BCA ASSESSMENT REPORT

PROJECT: COLES EXTENSION

ADDRESS: M7 BUSINESS HUB OLD
WALLGROVE ROAD, EASTERN CREEK

Date: 11 February 2013

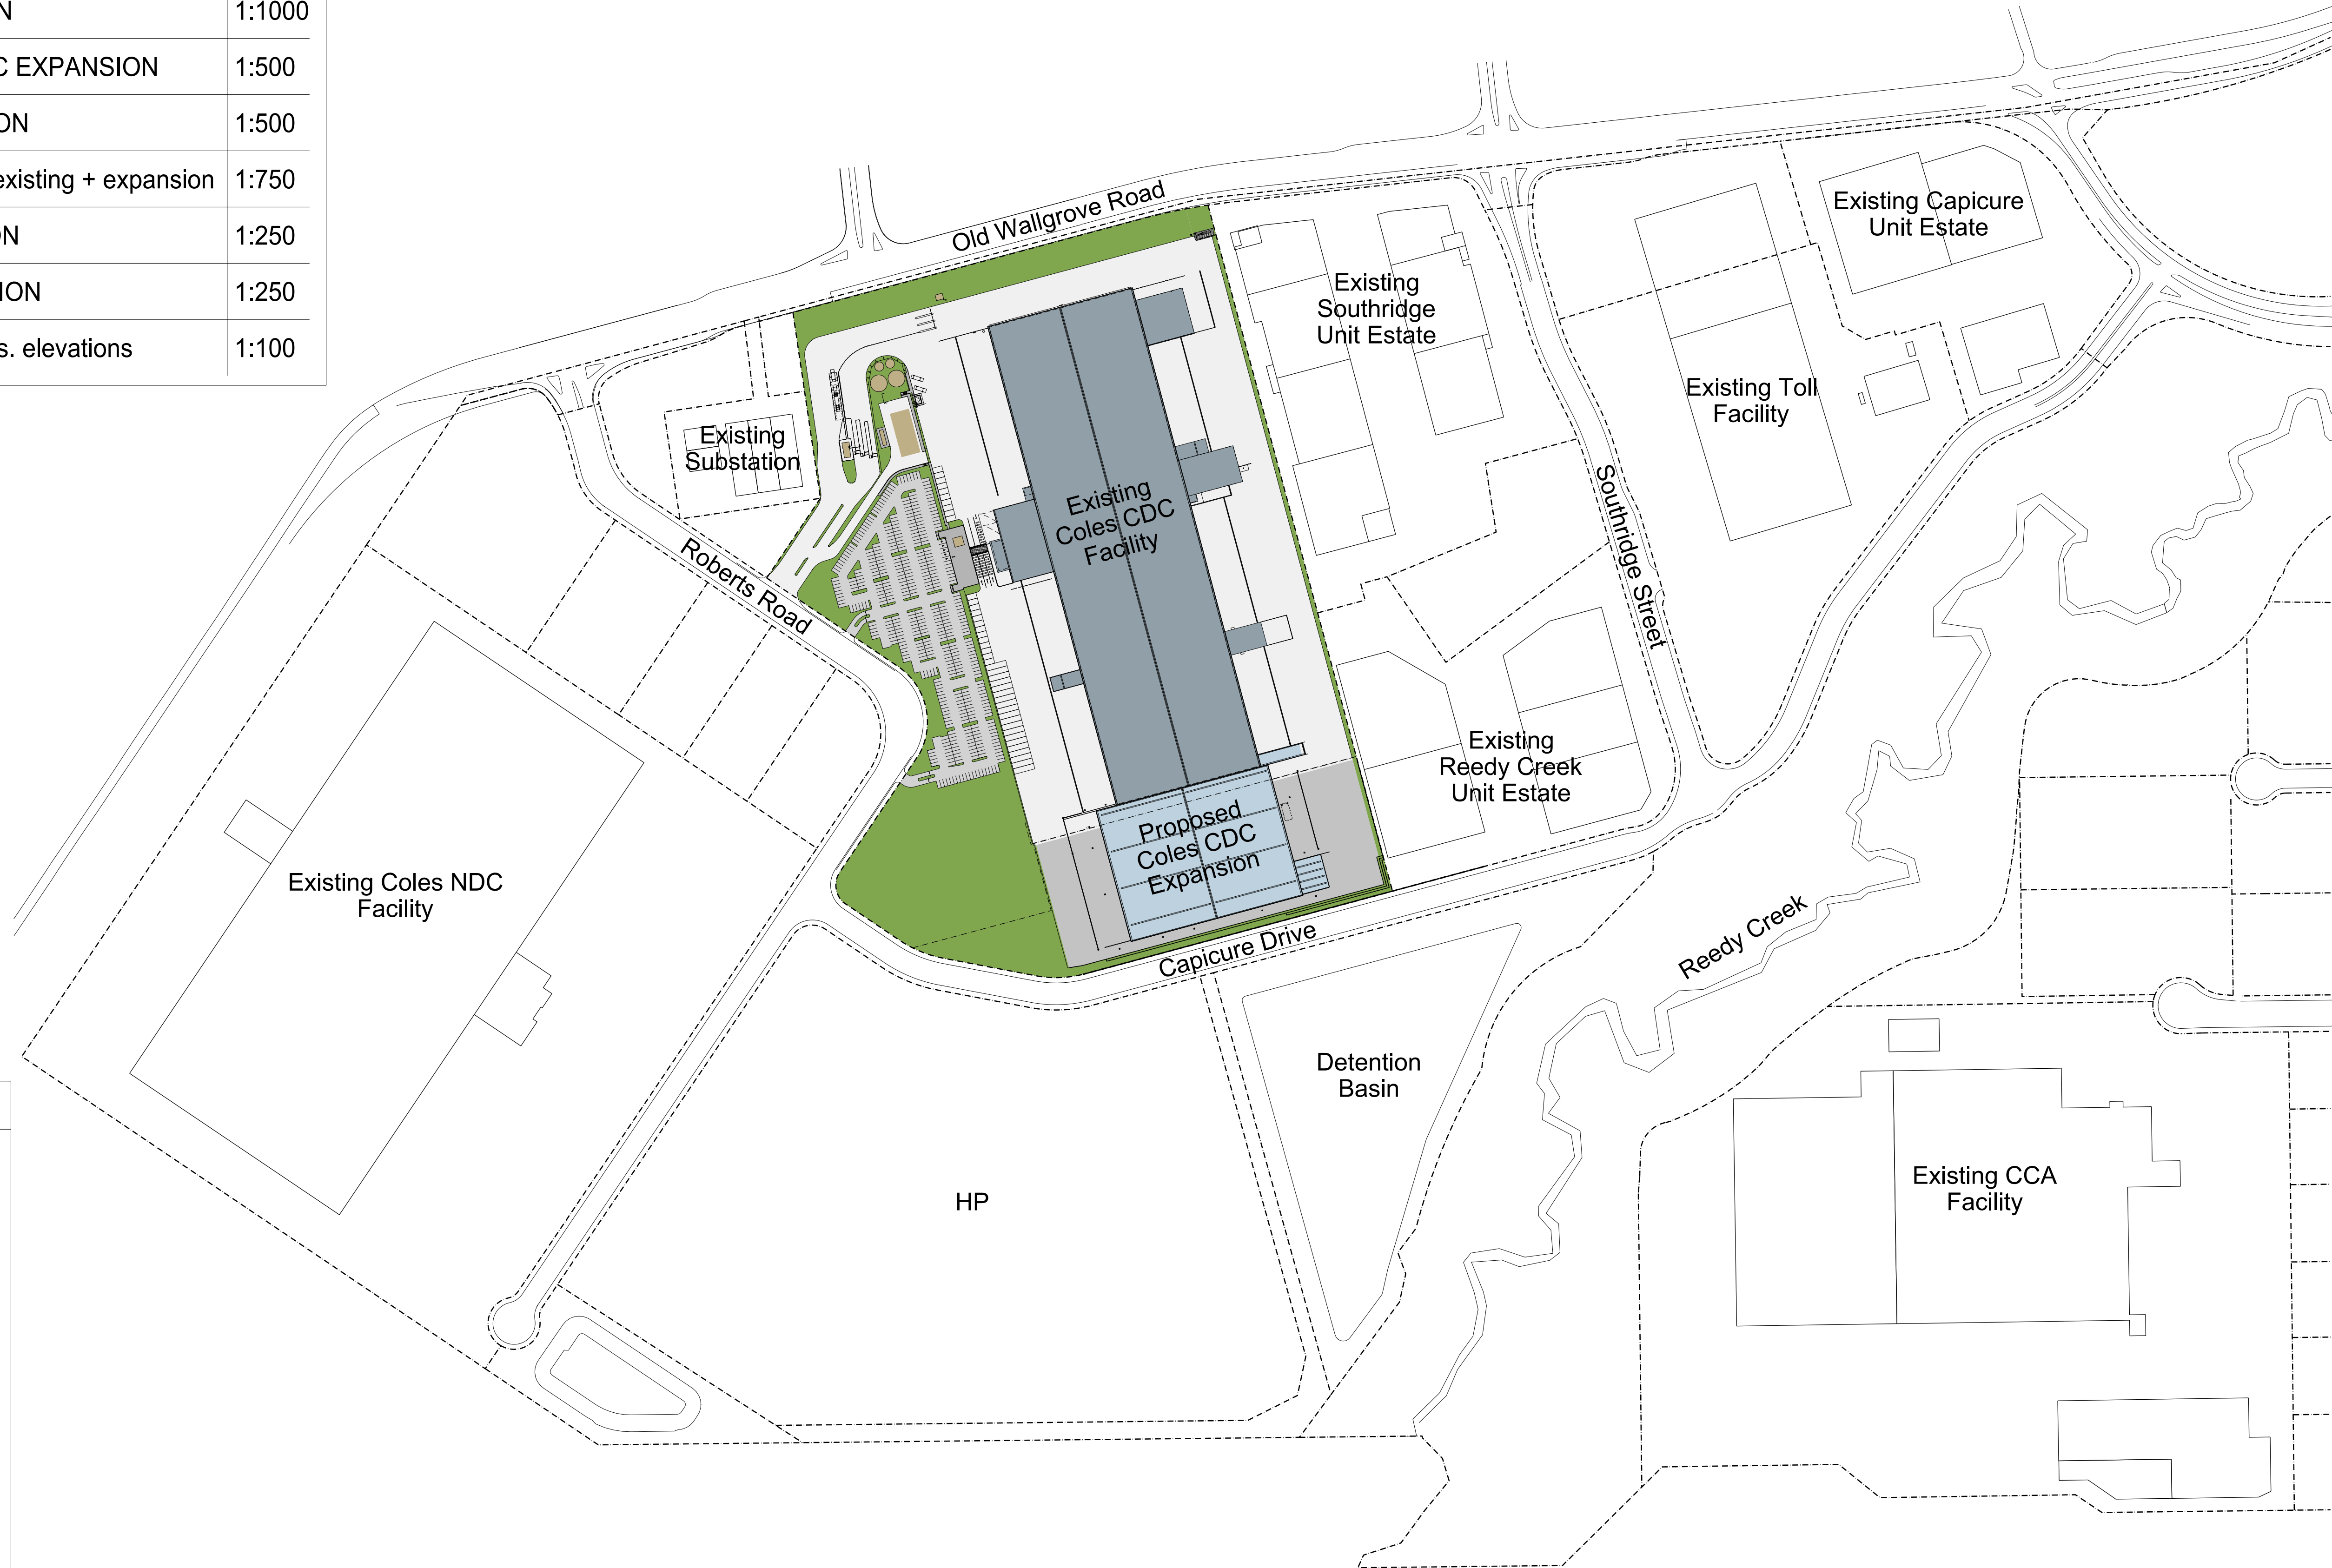
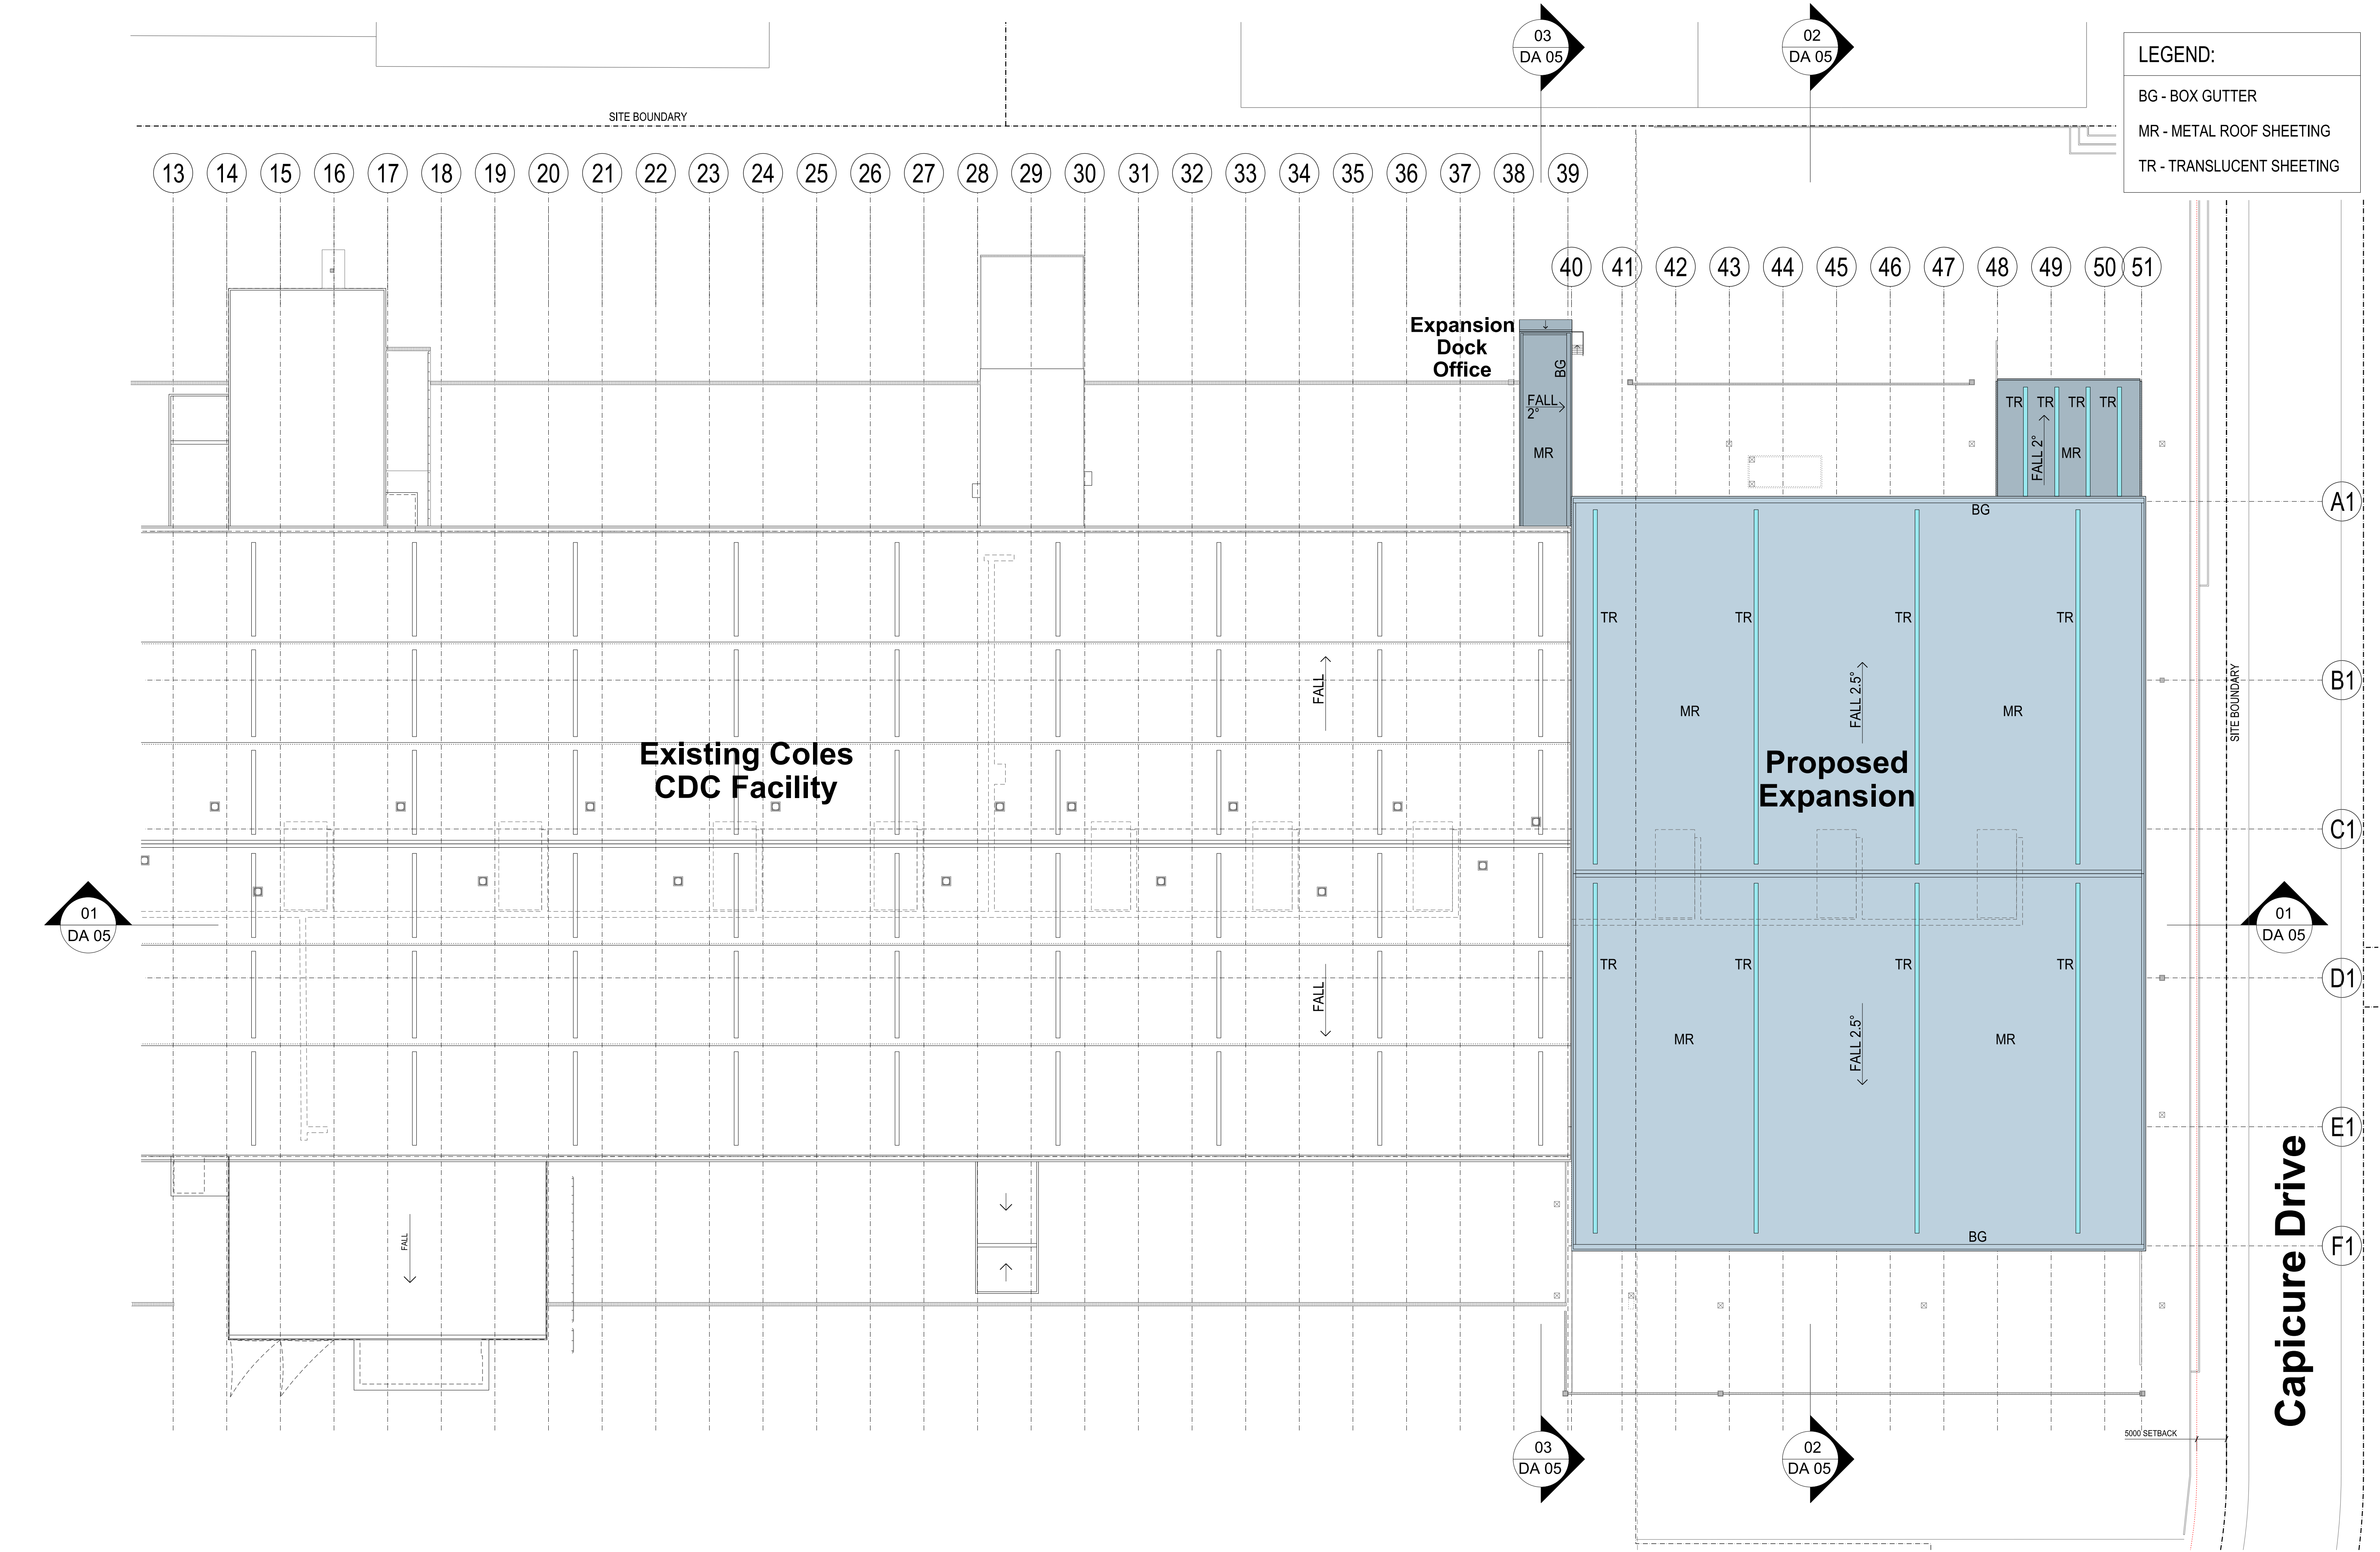
Comments: The proposed extension of the warehouse complies with the provisions of C2.4 in that a compliant 6m wide driveway is provided around the full perimeter of the proposed warehouse extension. Structural Certification of the load-bearing capacity of the driveway is required to be provided at CC Application stage.
